**KIRKLEES METROPOLITAN COUNCIL
INVESTMENT & REGENERATION SERVICE**

DELEGATED DECISION TO DETERMINE PLANNING APPLICATIONS

Reference No:	2025/62/93371/E
Site Address:	5, Dearnfield, Upper Cumberworth, Huddersfield, HD8 8NX
Description:	Erection of two storey side extension to west elevation, including single storey rear extension, two storey side extension to east elevation to replace existing single storey garage and associated alterations
Recommending Officer:	Jennifer Booth

DECISION - REFUSED

block plan
scale 1:200

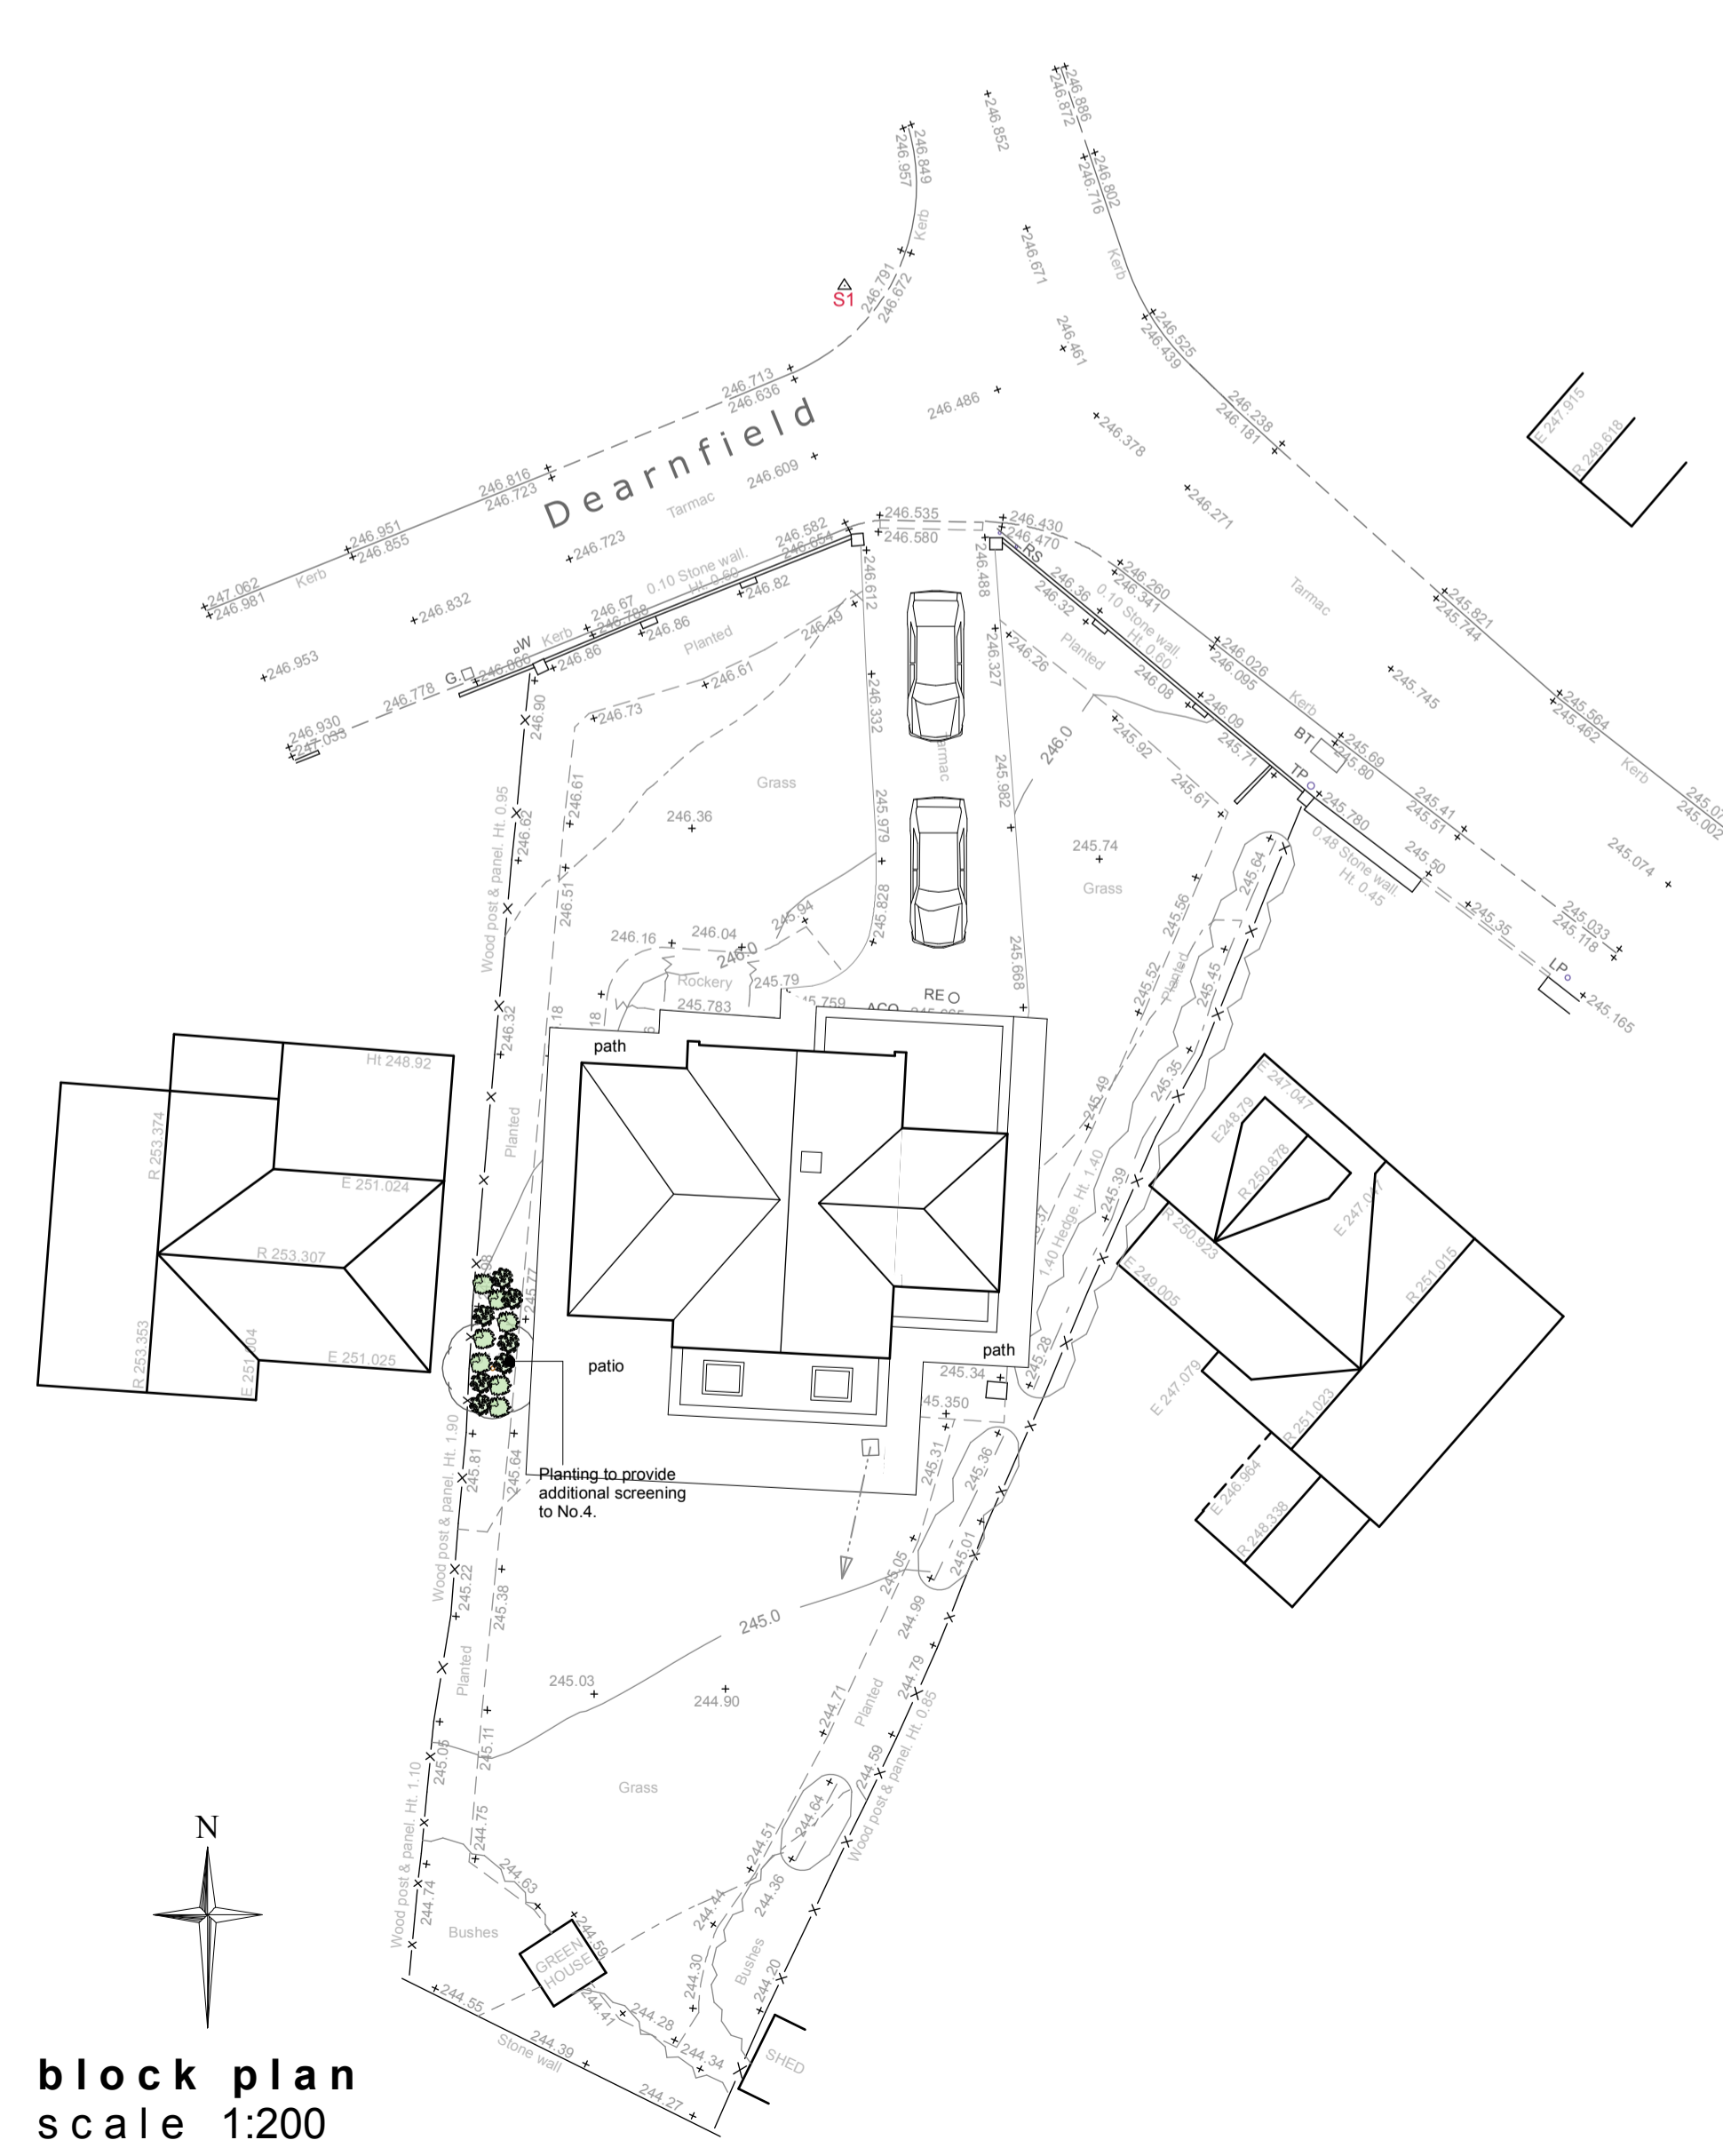
The current application demonstrates notable improvements from previous proposals, including increased front and rear setbacks, reduced ridge heights, and matching roof forms. These changes aim to address concerns regarding subservience and architectural coherence, with the applicant emphasizing compliance with the Kirklees House Extensions and Alterations SPD. However, the proposed extensions are still considered disproportionate to the host dwelling and fail to achieve a fully subordinate appearance. The scale and massing of the development remain excessive, and the design does not sufficiently overcome the previous reasons for refusal.

The applicant has argued that the cul-de-sac no longer retains a coherent architectural style due to significant modifications to neighbouring properties. While it is acknowledged that some properties have undergone alterations, the proposed dual aspect extensions to both sides of the dwelling, combined with its prominent siting, result in a bulky and incongruous development. The extensions are larger and more dominant than any other property in the street, disrupting the character and appearance of the area and creating an unbalanced composition.

Officers conclude that the application does not adequately address the previous reasons for refusal, as the extensions continue to appear overly dominant and inconsistent with the character of the area. Consequently, the proposal fails to comply with Policy LP24 of the Kirklees Local Plan (a) in terms of the form, scale and layout and (c) as the extension would form a

The proposed extensions and alterations, due to the design and scale would not form subservient additions to the property and would result in a contrived and unsympathetic appearance which would be harmful to the character of the host property and the surrounding area. To permit the proposals would be contrary to Policy LP24 of the Kirklees Local Plan, KDP1 & KDP2 of the House Extensions & Alterations SPD and advice within Chapter 12 of the National Planning Policy Framework.
